Your ref:
Our ref: 22/00345/F
Please ask for: Miss Sandra Homcenko
Direct dial: 01553 616824
E-mail: borough.planning@west-norfolk.gov.uk

Details: **Proposed Replacement Dwelling and Garage (Self-Build) at Holkham View 115
Burnham Road North Creake Norfolk NR21 9LB**

I have received a planning application as detailed above but cannot process it until I receive some more information:

Existing and Proposed Site Plan 1:500

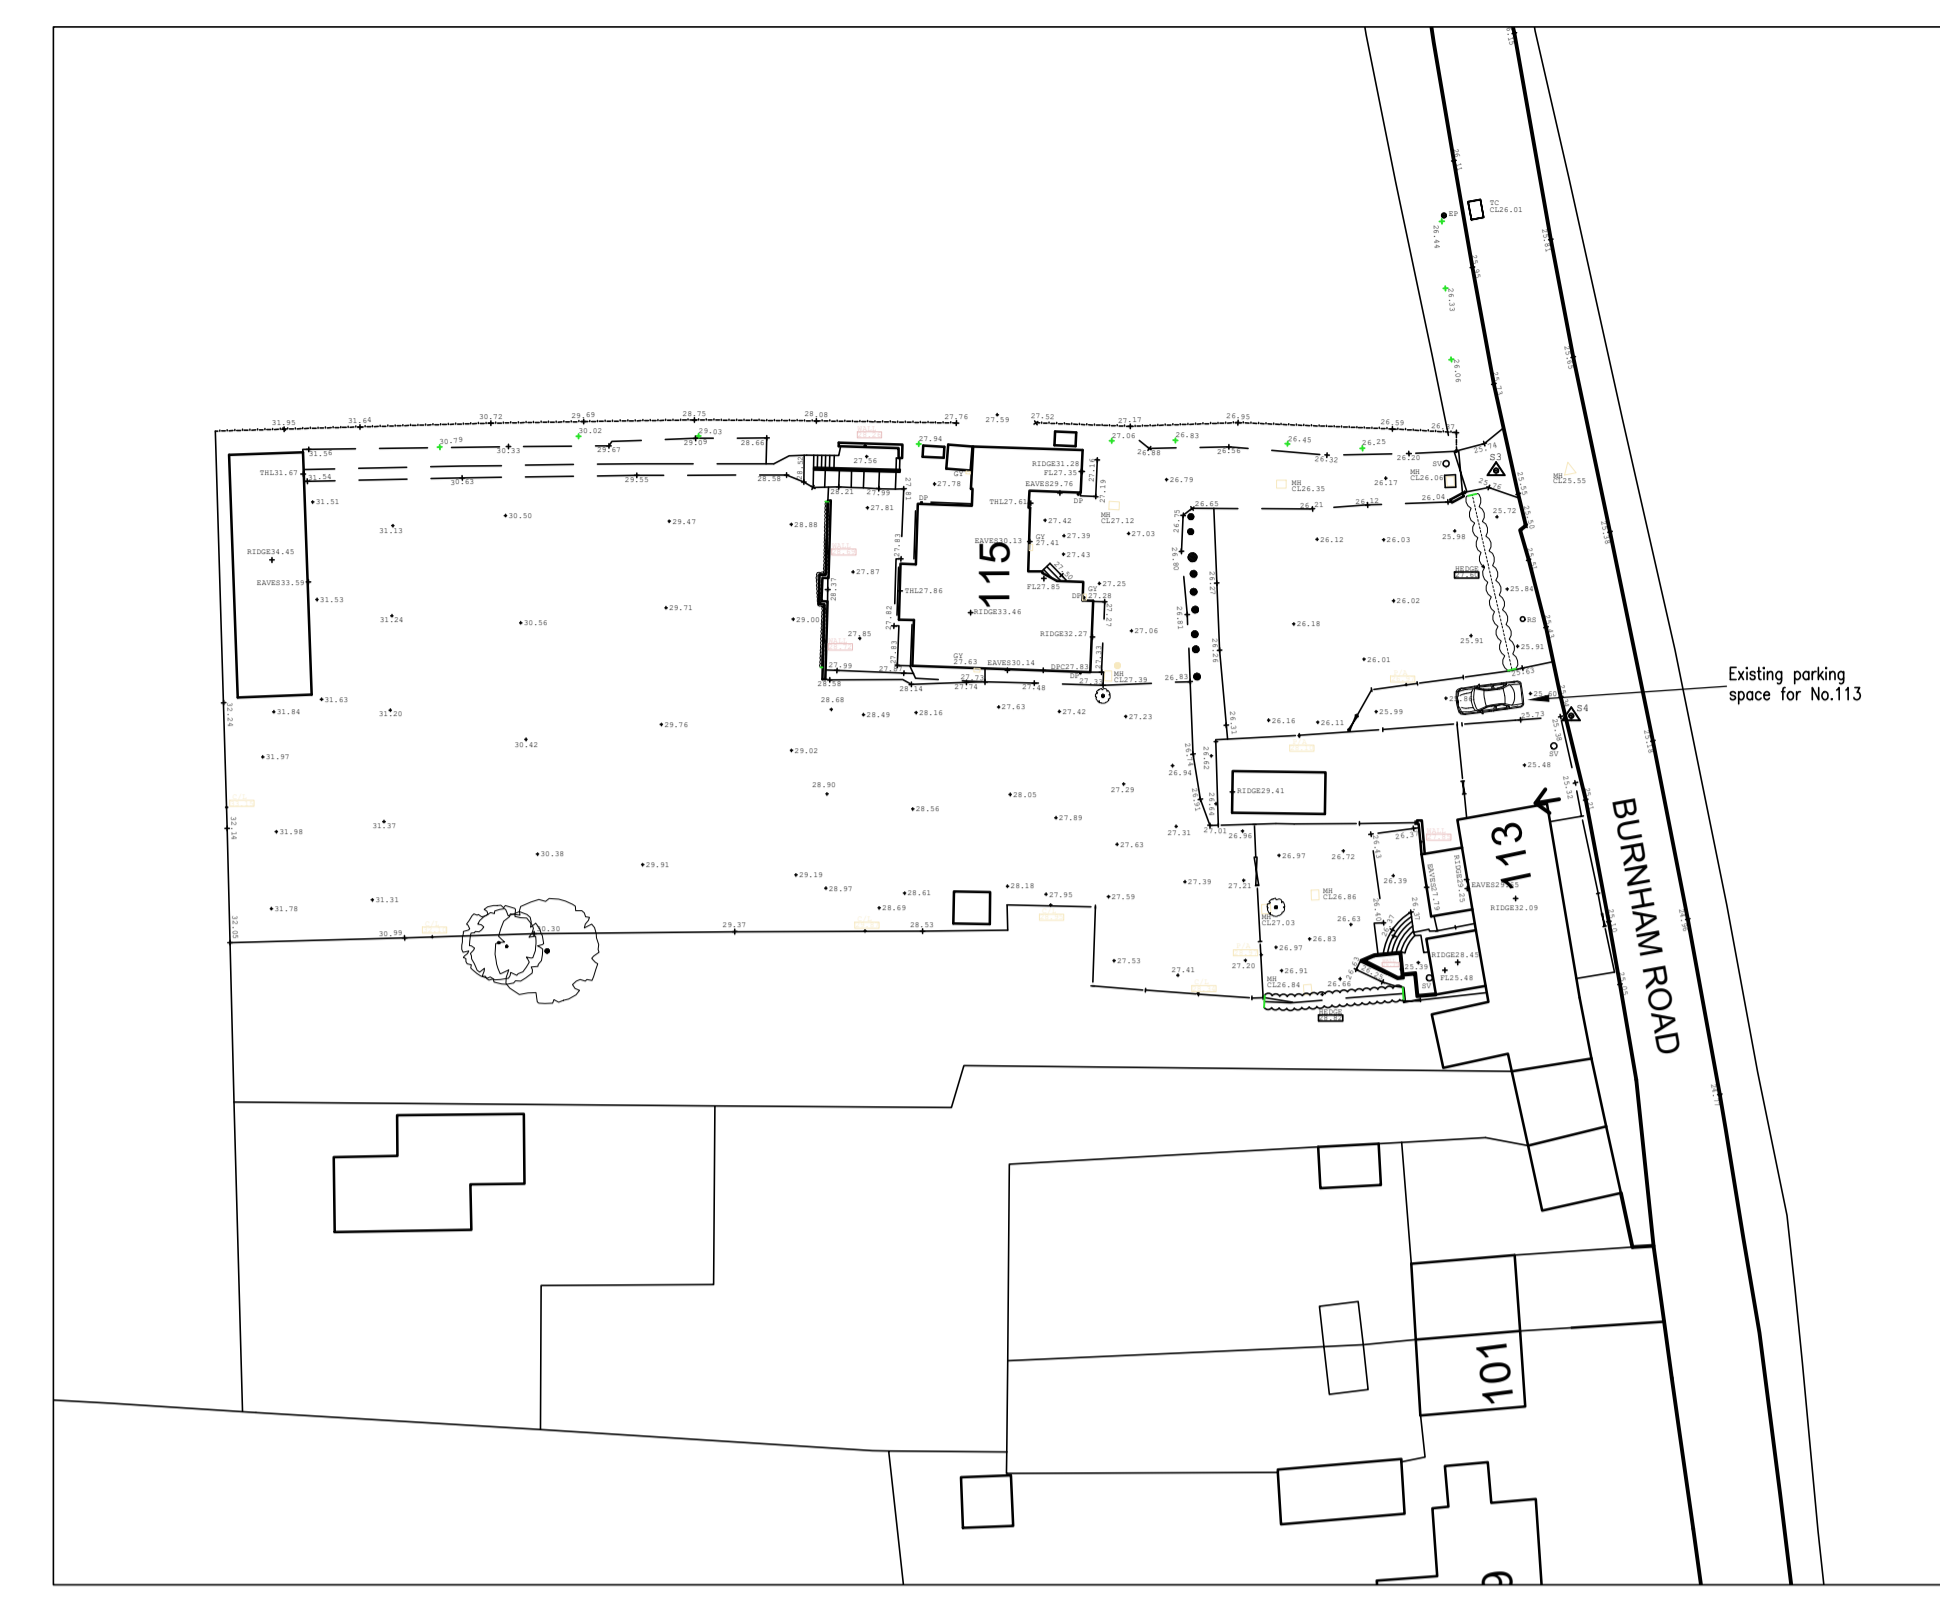
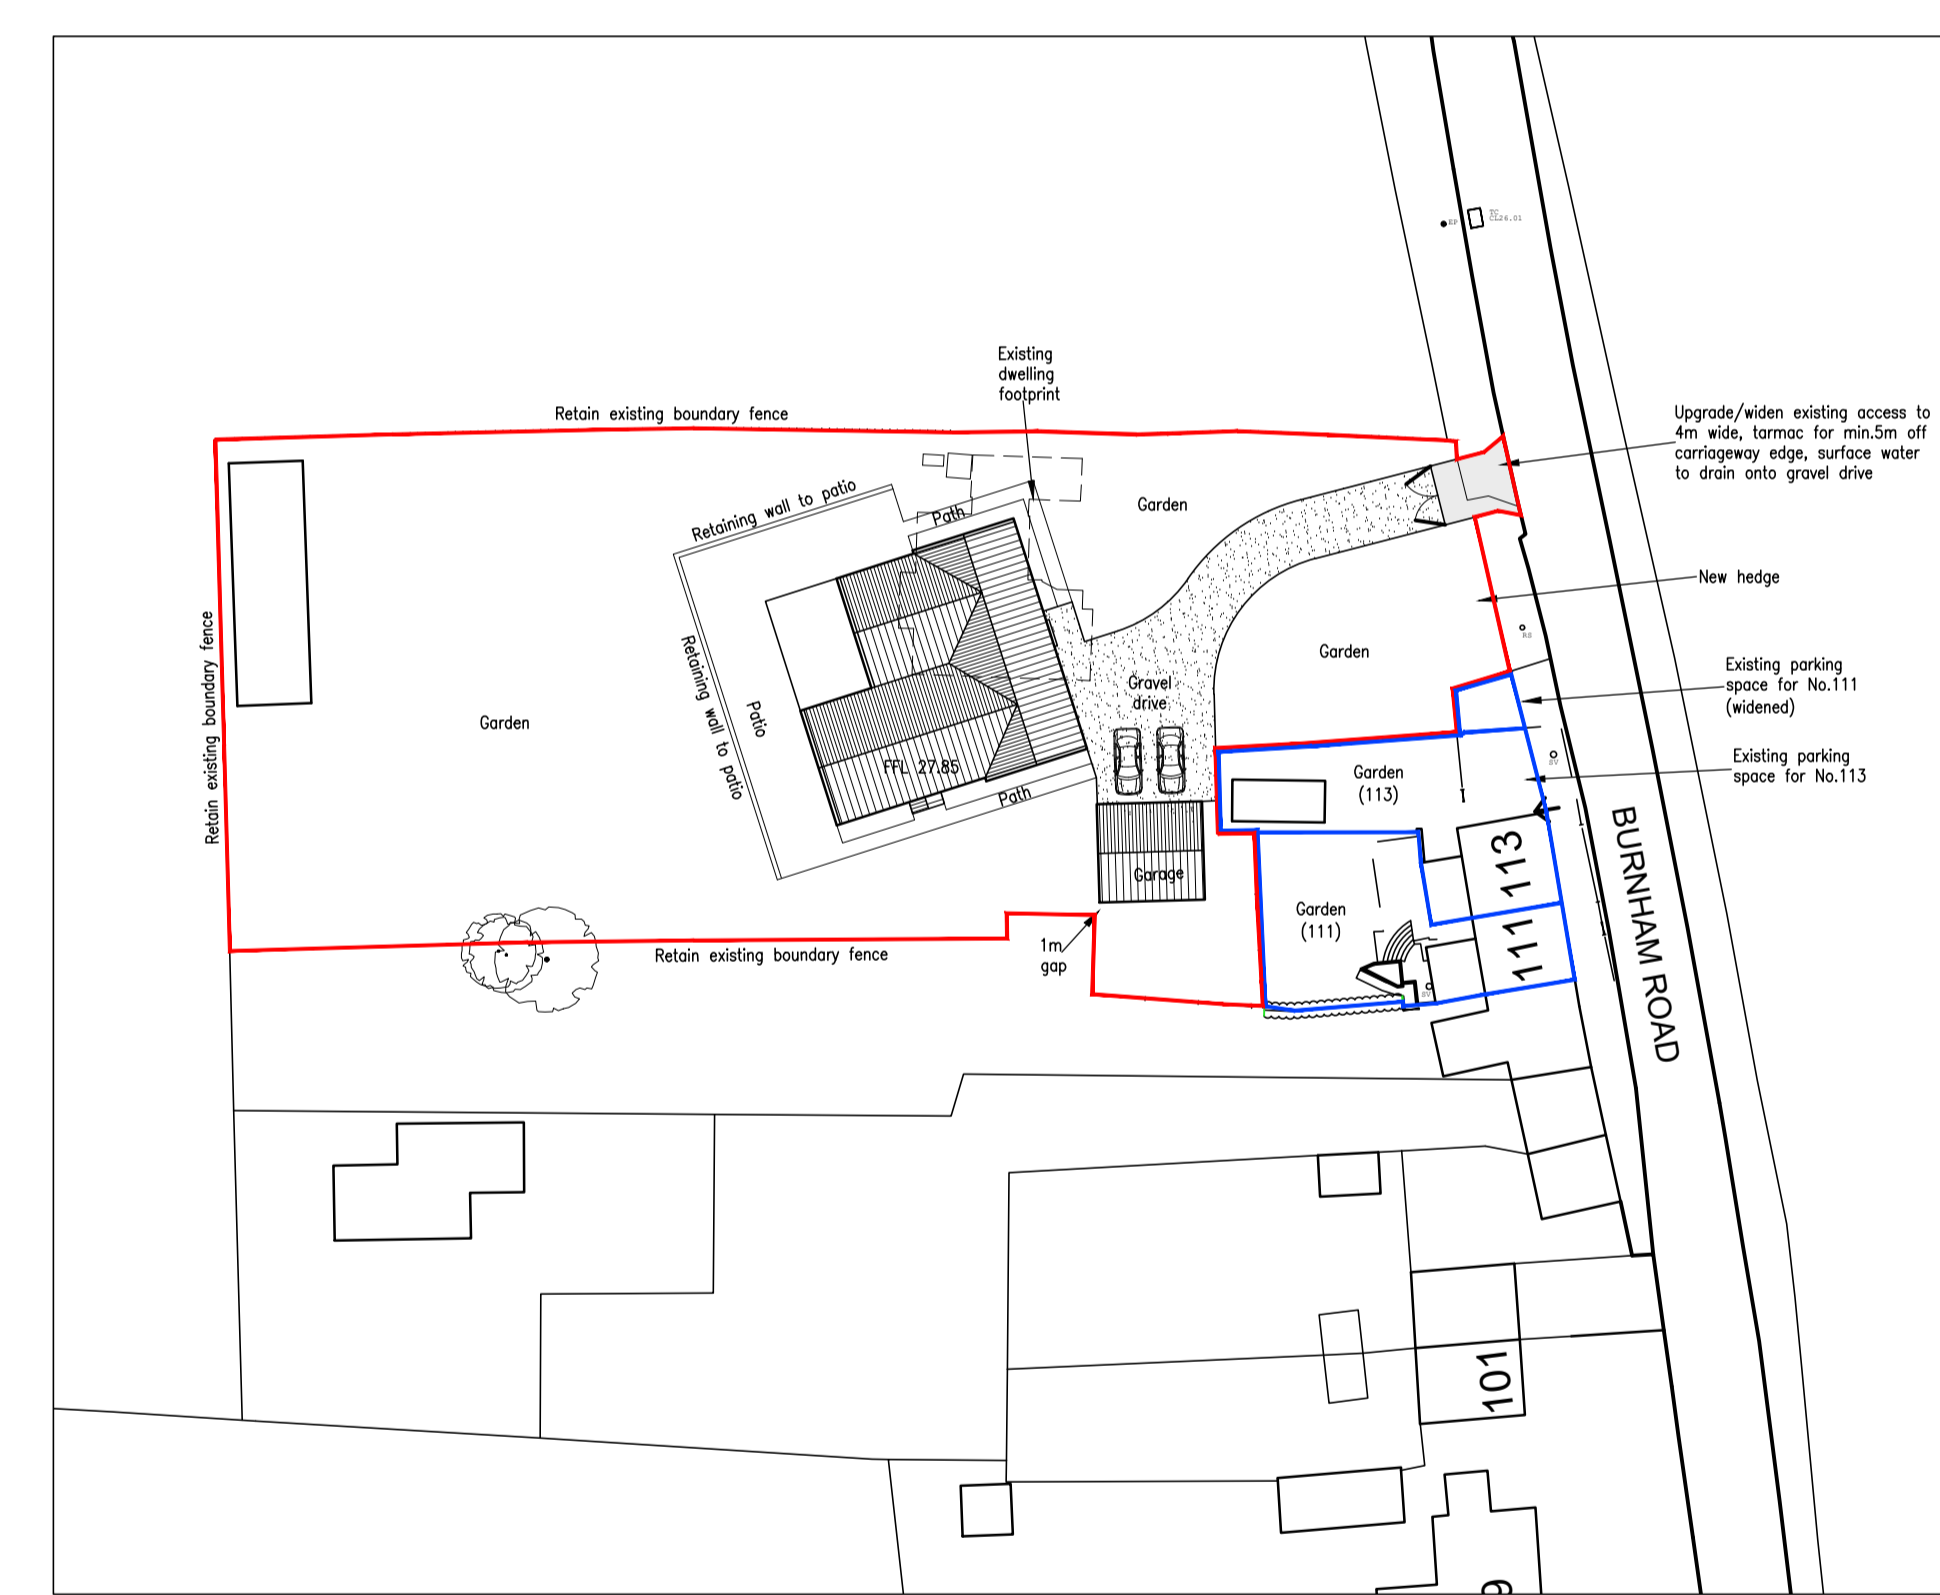
1. Please confirm what are you trying to show with "Previous Side Elevations"?
2. Please provide drawings to a recognisable scale, showing existing and proposed site levels. If the site levels are to remain unchanged, please provide the drawings annotated as existing and proposed.
